**From:** [Griffiths, Bryn](#)  
**To:** [Wylfa Newydd](#)  
**Cc:** [Wylfa Newydd DCO](#); [Energy Island](#); [Aron, Henry](#)  
**Subject:** Natural Resources Wales: Deadline 4 submission - Wylfa Newydd Nuclear Power Station (Our ref: 20011606)  
**Date:** 17 January 2019 15:36:27  
**Attachments:** [2019 01 17 Deadline 4 submission - NRW.PDF](#)

Deadline 4 submission, including NRW's case put orally at the January ISHs – Our ref: 20011606

### **GORSAF BŴER NIWCLEAR ARFAETHEDIG WYLFA NEWYDD / PROPOSED WYLFA NEWYDD NUCLEAR POWER STATION**

#### **RE: NATURAL RESOURCES WALES' CASE PUT ORALLY AT THE ISSUE SPECIFIC HEARINGS HELD IN JANUARY 2019**

WN0902-HZDCO-LFM-DRG-00026	ECOLOGICAL COMPENSATION SITE, CORS GWAWR, EXISTING SITE PLAN
WN0902-HZDCO-LFM-DRG-00027	ECOLOGICAL COMPENSATION SITE, CORS GWAWR, PROPOSED SITE LAYOUT

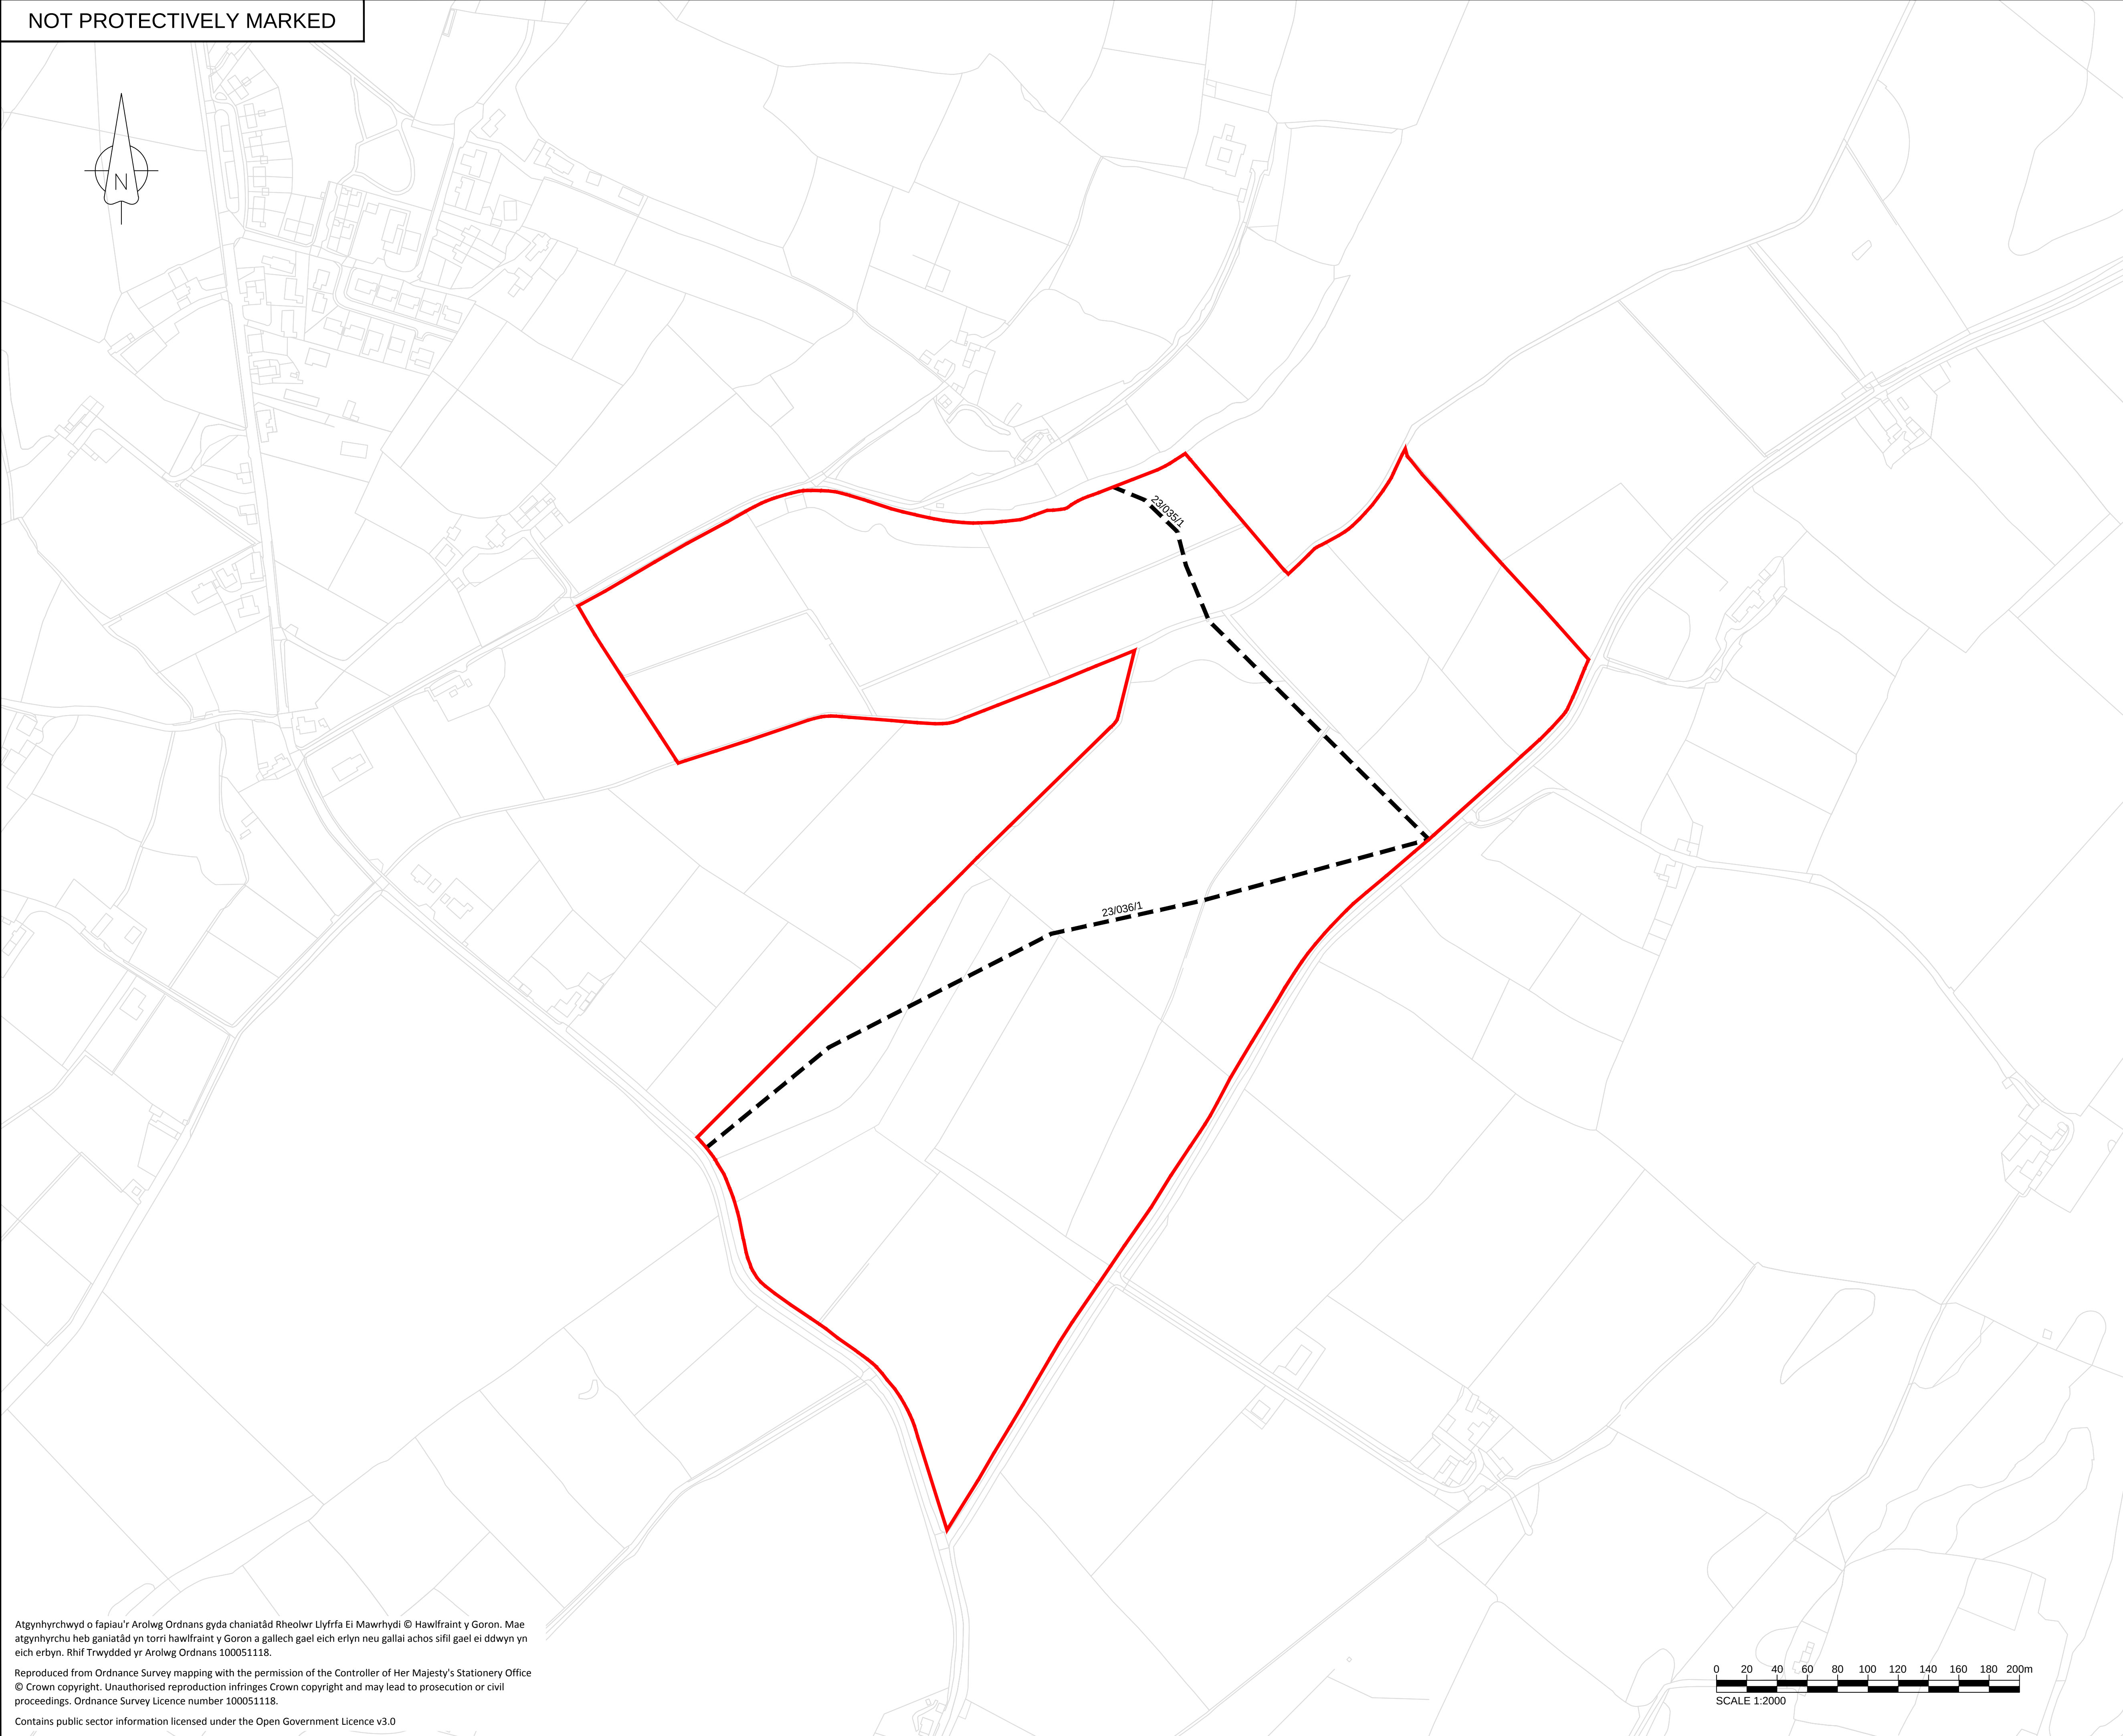
3.12.1. NRW consider that there is insufficient information on the pre-emptive compensation sites (Cors Gwawr and Cae Canol Dydd) to have confidence in the proposals. In particular, hydrological data supplied for these sites is inadequate, which means that their hydrology currently is not adequately understood.

3.12.2. In both cases, there are existing areas of fen which can be enhanced by managing apparent water sources (e.g. springs and streams) so that they are extended to irrigate a larger area. However, there is no adequate data on groundwater regime or streamflow on which to base any projection of the quantity or quality of wetland that could be created.

3.12.3. Preliminary hydrological survey suggests that there are probably groundwater and surface water resources that could provide *some* appropriate conditions to create fen wetland, but this has not been quantified. It is therefore not possible at this time to conclude with confidence that enough water of adequate quality is available to create the proposed fen habitat.
